LAND WEST OF B2132 BILSHAM ROAD, YAPTON

**STAGE 1 ROAD SAFETY AUDIT DESIGNERS RESPONSE
DROVE LANE SITE ACCESS**

**STAGE 1 ROAD SAFETY AUDIT DESIGNERS RESPONSE
A259 OYSTERCATCHER IMPROVEMENT SCHEME**

-  HIGHWAY BOUNDARY (EXTRAPOLATED FROM PLAN PROVIDED BY WEST SUSSEX COUNTY COUNCIL)
-  2.4m x 59m VISIBILITY SPLAY (UPTO 37mph MFS IN ACCORDANCE WITH OBSERVED 85th PERCENTILE SPEEDS OF 35mph NORTHBOUND & 36mph SOUTHBOUND)

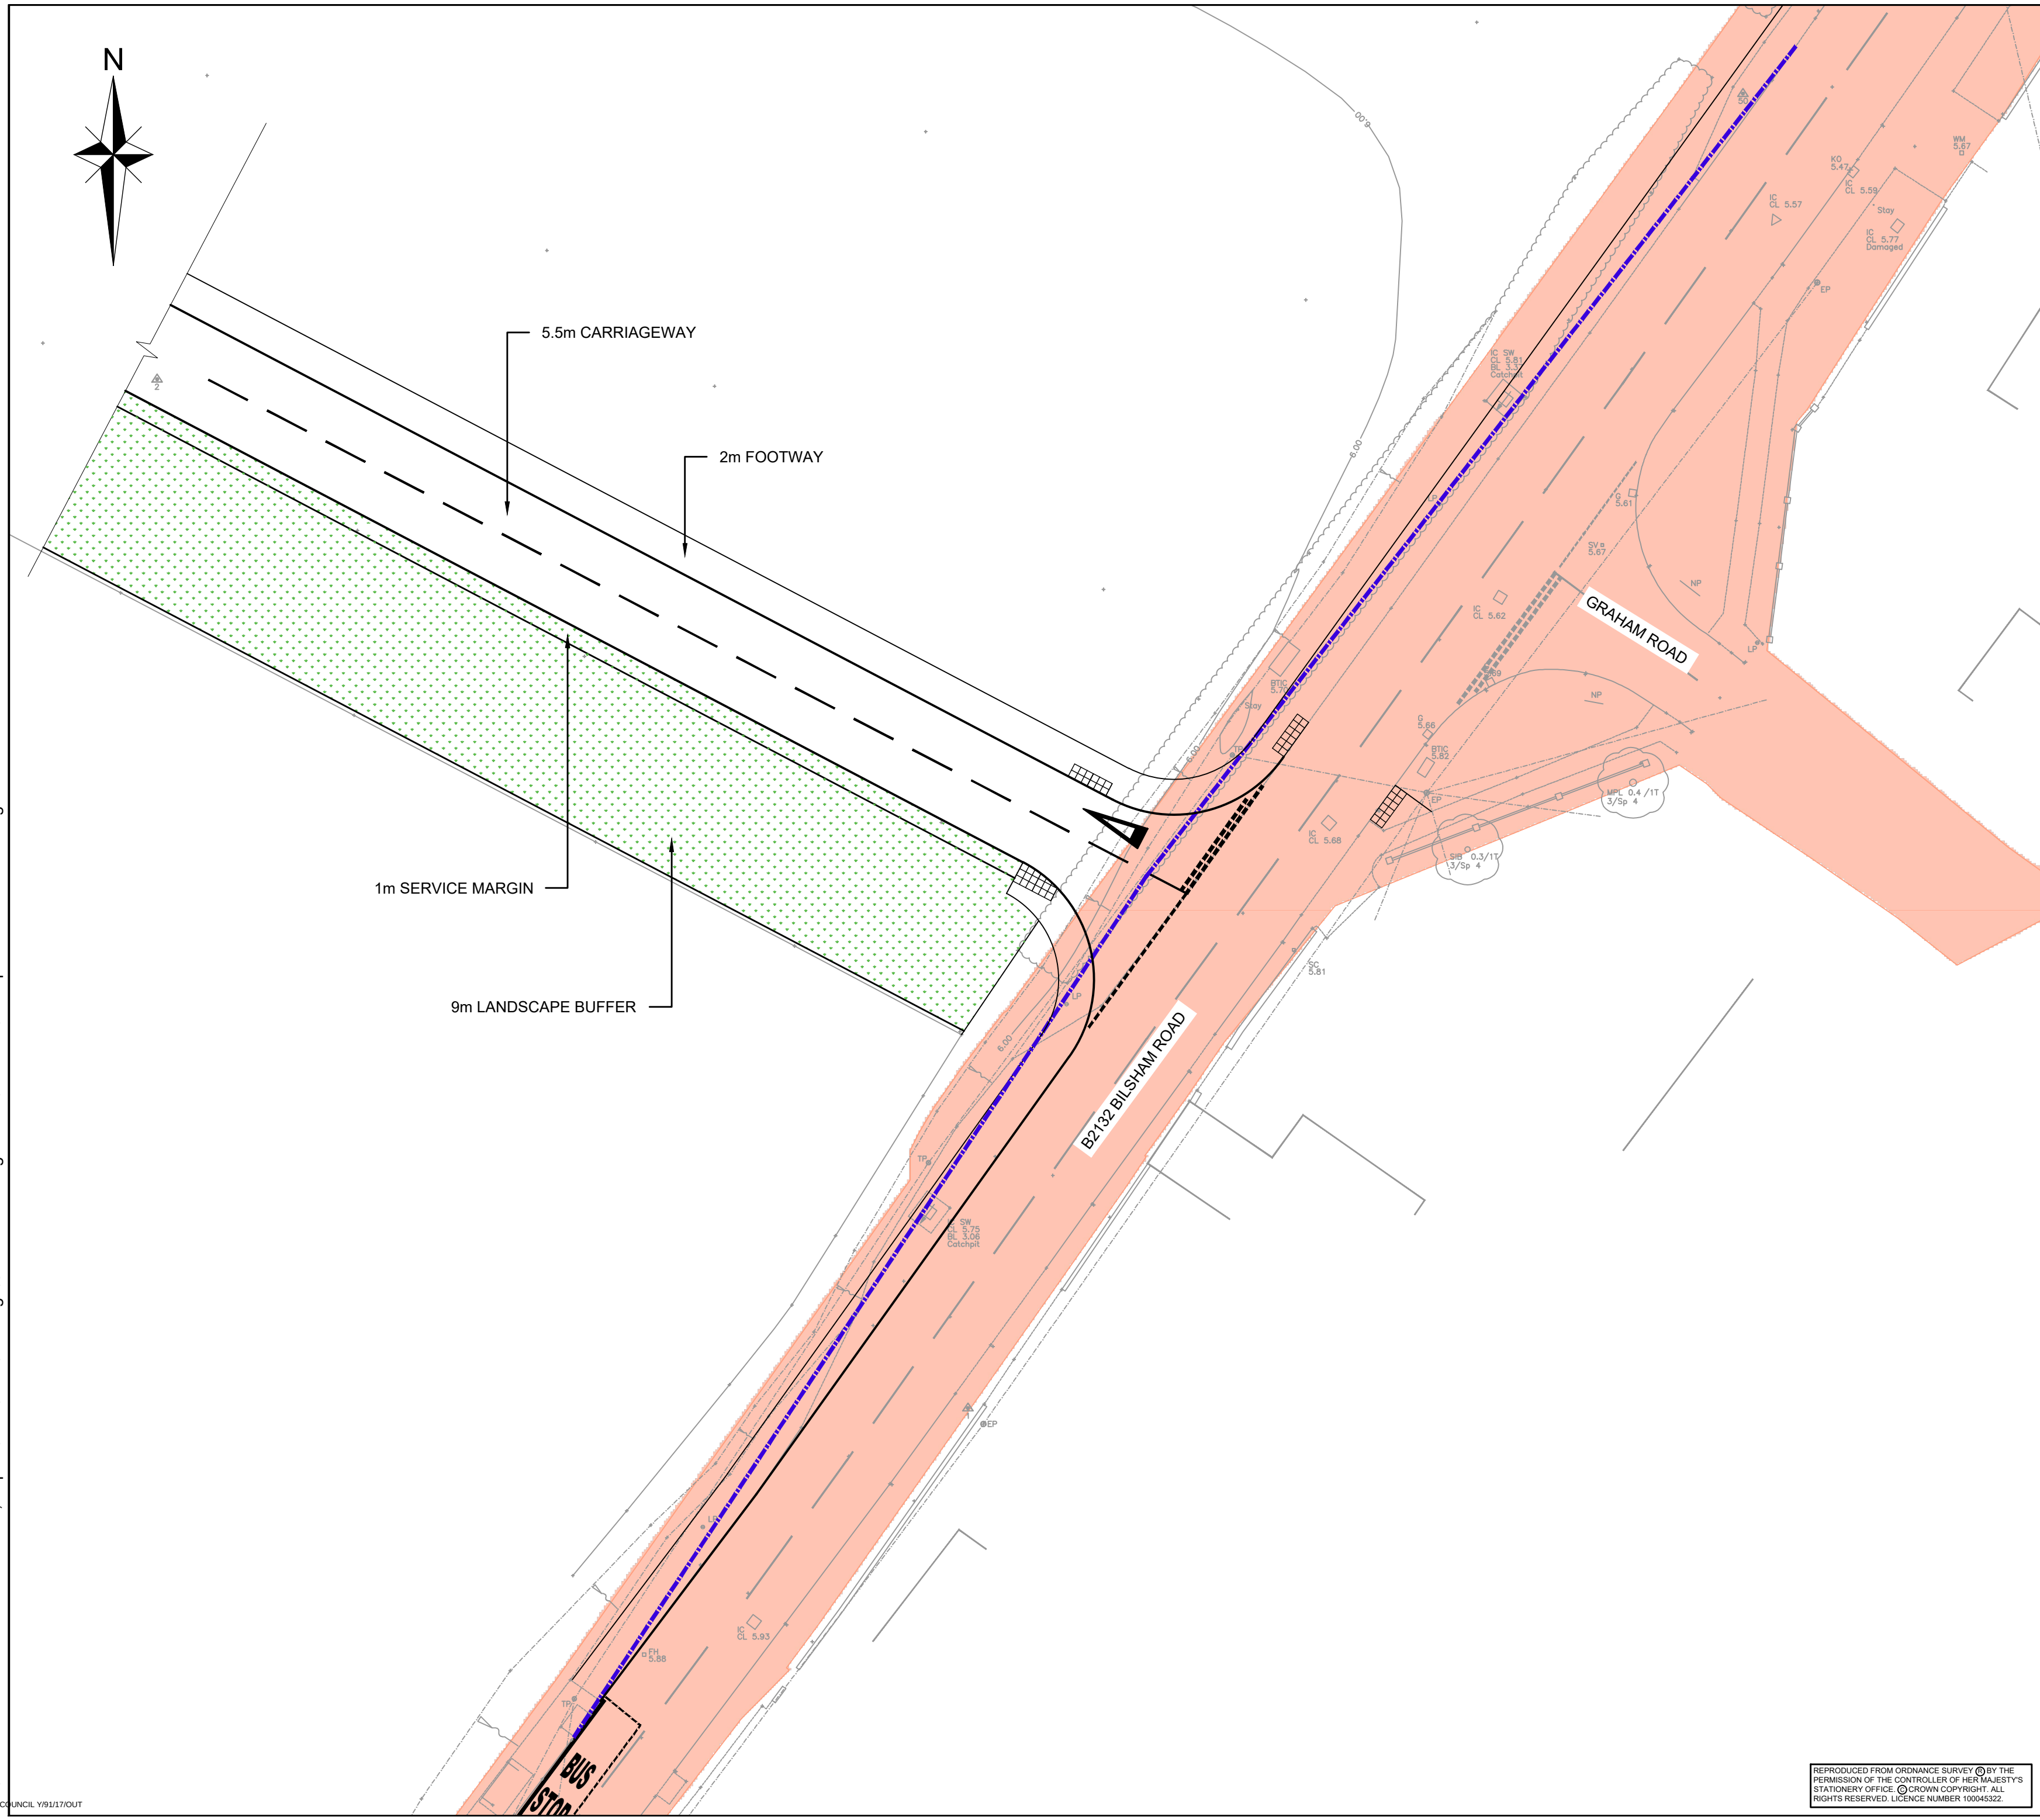
Audit Item No.	Audit Team Observation	Audit Team Recommendation	Designers Response
3.0	Matters Arising From This Stage 1 RSA		
Location	Gladstone Road		
3.1	No hazard paving is proposed at the start/termination of the shared footway/cycleway at Gladstone Road. This could result in pedestrians being unaware they are entering a shared facility or cyclists continuing to cycle on footway not designated as shared, increasing the risk of collisions between pedestrians and cyclists.	Provide hazard paving and appropriate signing to highlight start/termination of the shared facility.	Agreed, appropriate paving will be provided to show the start / termination of the shared walking and cycling facility. Drawing 14-111/003-A illustrates.
Location	Bilsham Road

3.2	There is no pedestrian crossing facility proposed to the north of the proposed access for pedestrians wishing to cross Bilsham Road when travelling to and from the development. The absence of a pedestrian crossing facility could result in pedestrians with impairments falling/stumbling on full height kerbs. It may also lead to pedestrians attempting to cross at locations drivers will not be expecting them increasing the risk of vehicle/pedestrian collisions.	Provide an uncontrolled pedestrian crossing on Bilsham Road north of the proposed access.	An uncontrolled pedestrian crossing has been added to the on the northern side of proposed access. Drawing 14-111/003-A illustrates.
-----	--	--	--
